I hope you're having a fun Summer. This is a blast from your past—a building permit for a new Verizon Wireless building on Congress Street that was issued earlier this year. I've attached the approved plan and our proposed revision. As part of this change we're going to:

**Subject:** Re: [1531 Congress St.](#), BP# 2017-00260 plan review comments

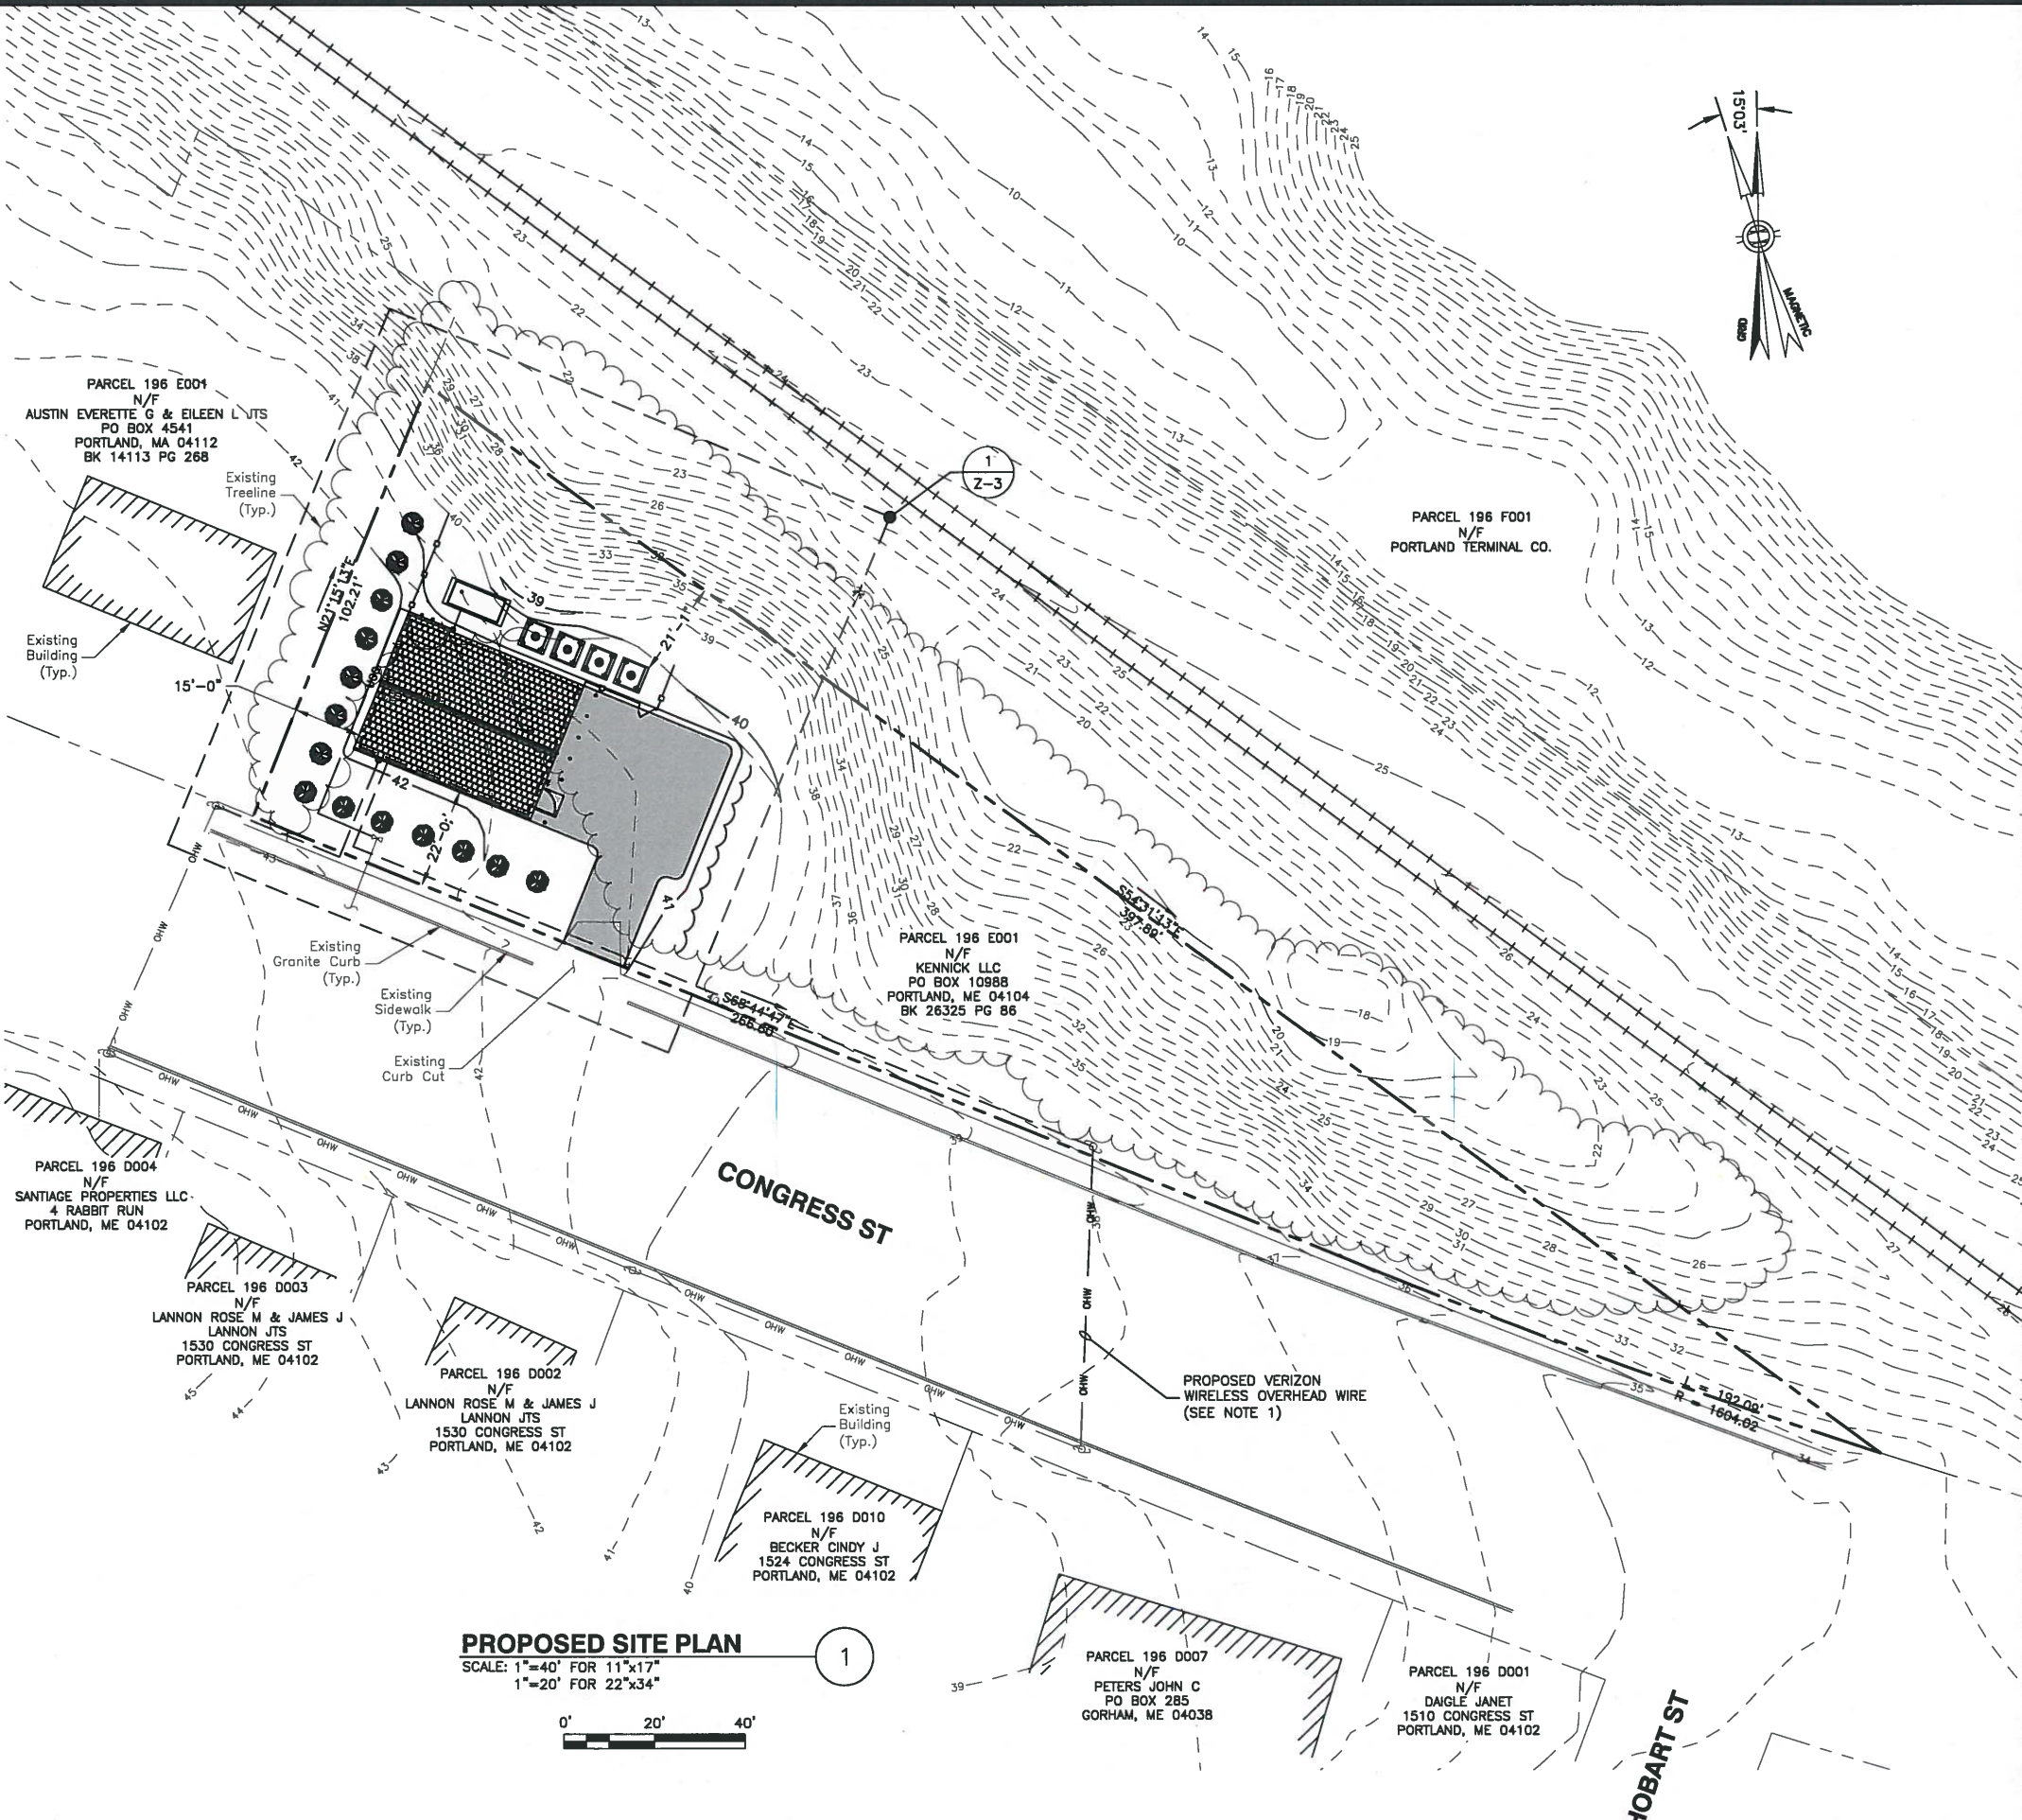
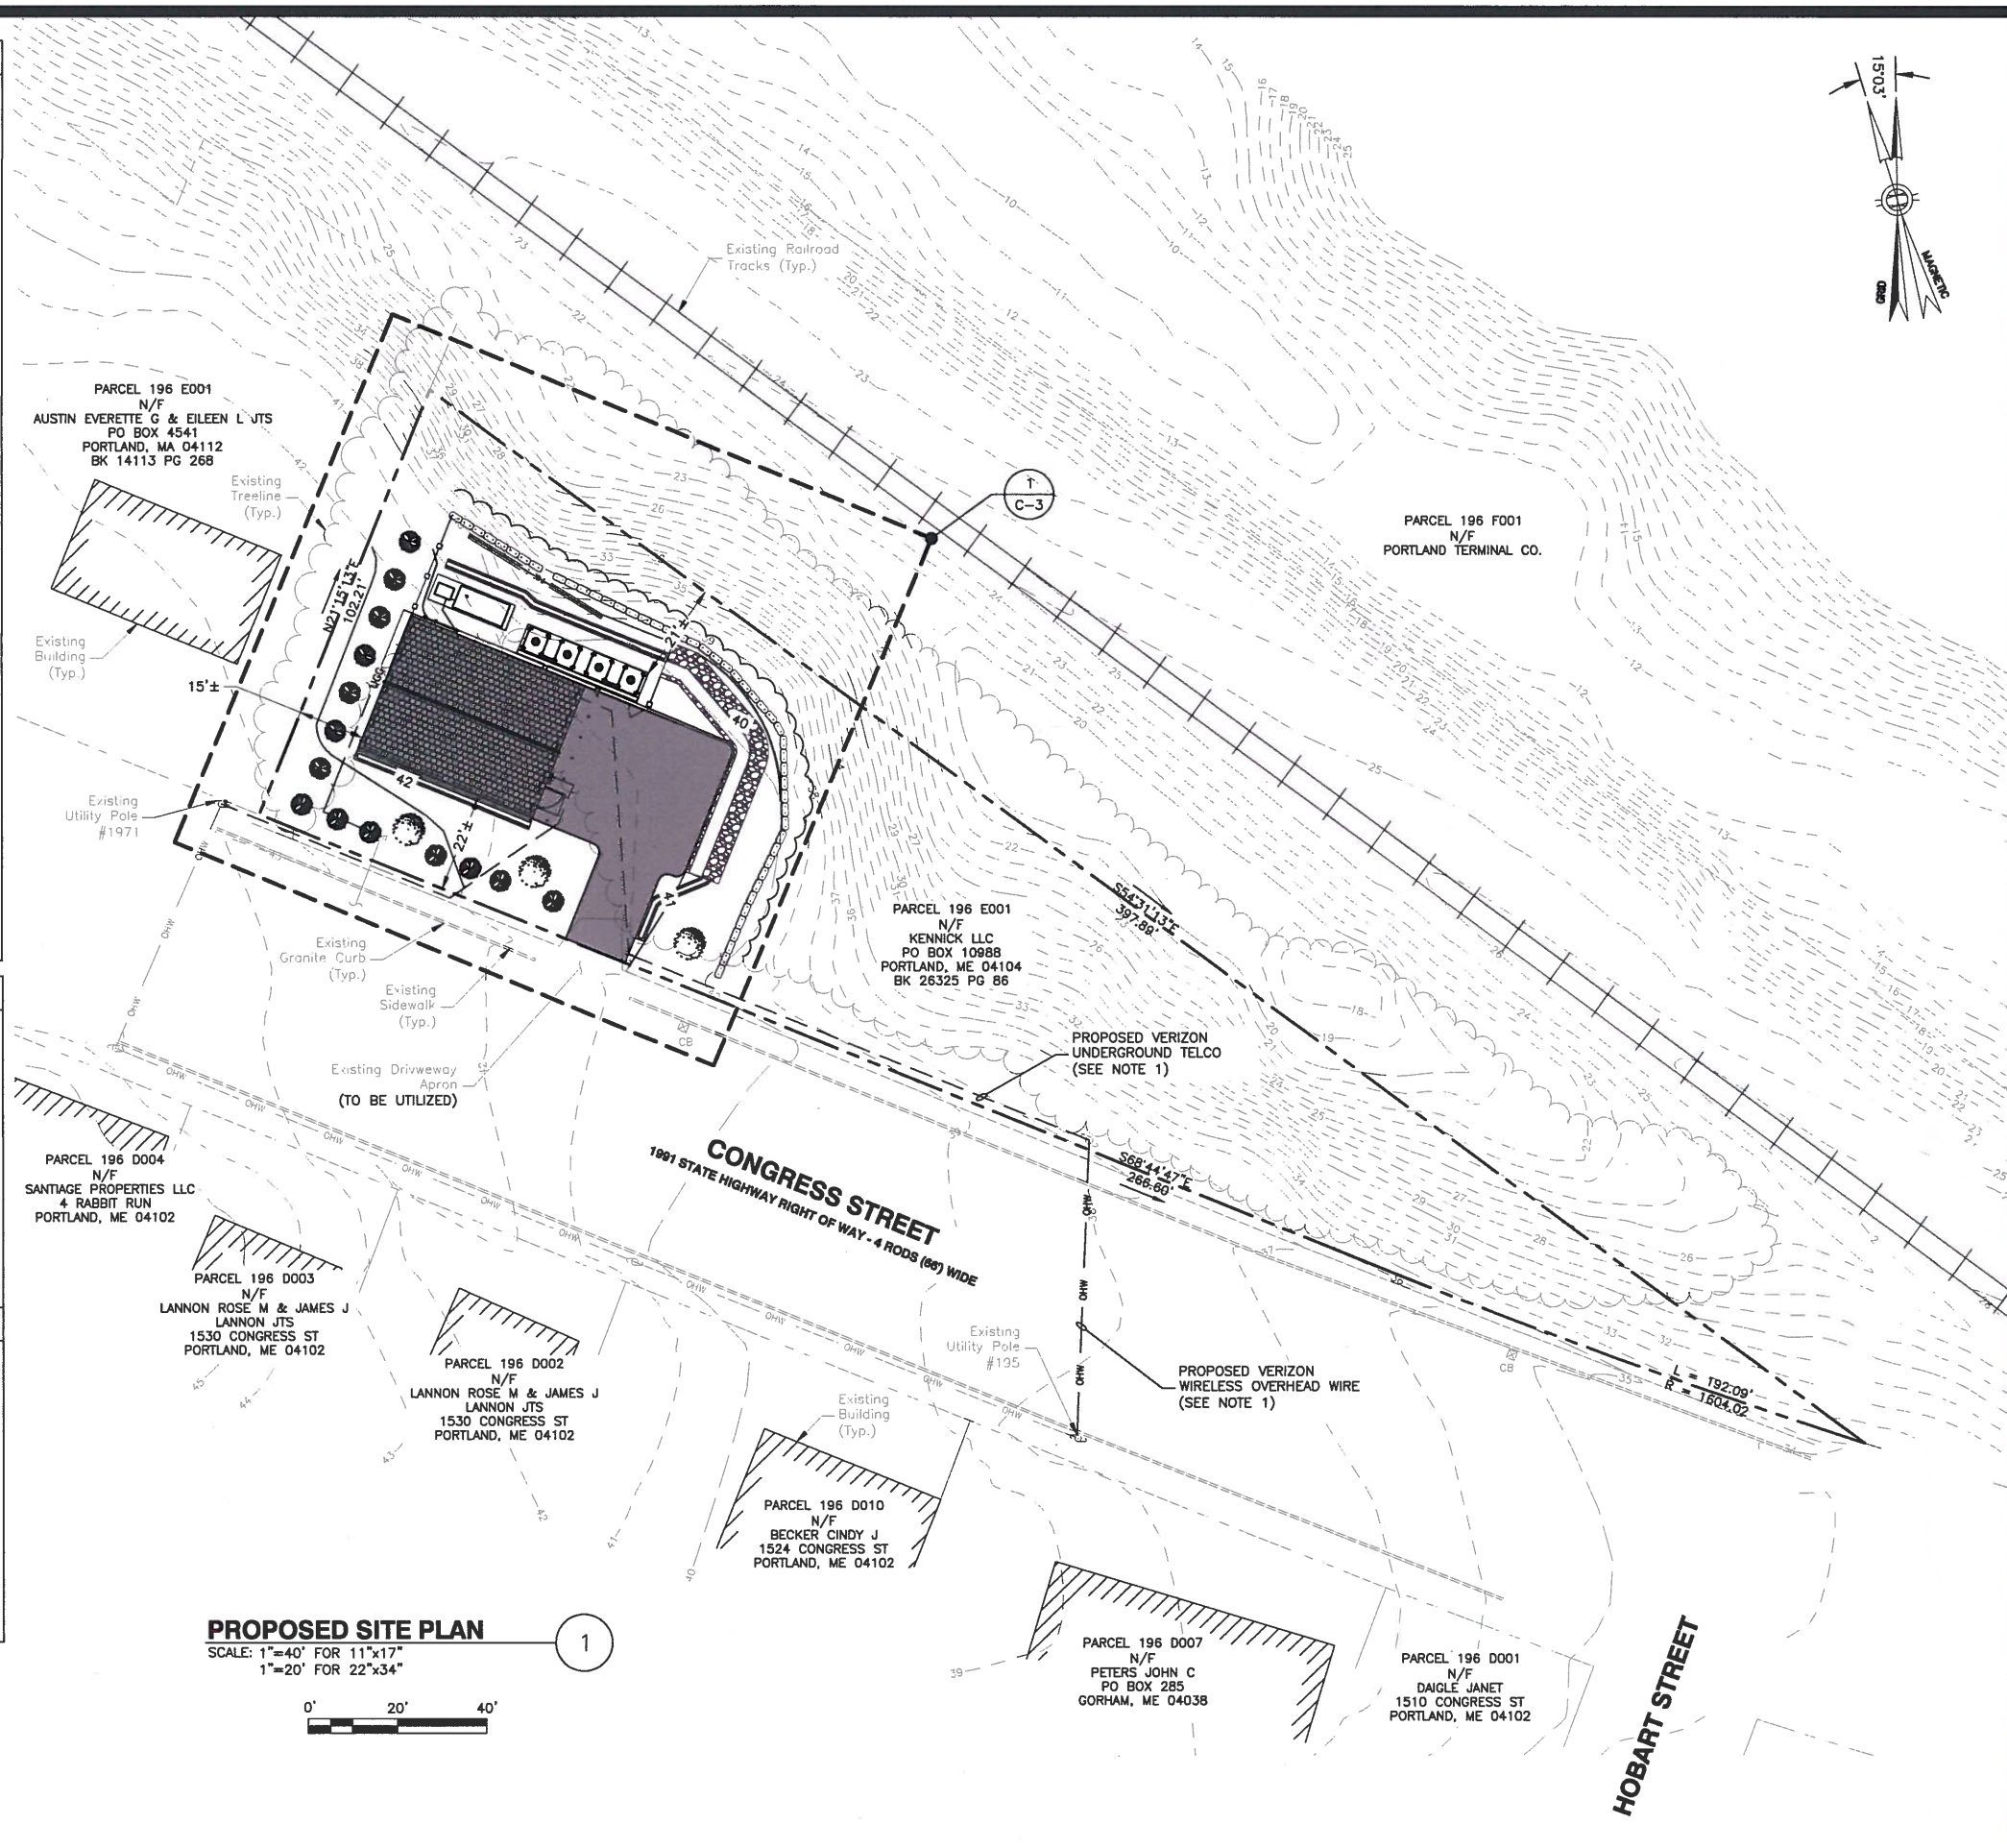
1. Move the back-up generator inside;
2. Reduce the HVAC units from 4 to 2;
3. Add a second door on the right hand side of the structure; and
4. The roof will be metal, not shingles.

Thus, the changes will actually result in a reduction in the footprint of the outside improvements, and there will be no changes to the building size, driveway/parking areas, plantings, light, dust etc. Also, noise levels will be quieter as the generator is inside and the number of HVAC units has been reduced.

As far as the list of proposed changes to the approved design, we will consider these as, as built modifications and the revised plans and details can be directly submitted to me to review and file with the permit documents.

Kind of, no amendment, but the as built plans need to be submitted to me prior to inspections, for purview and for the file record.
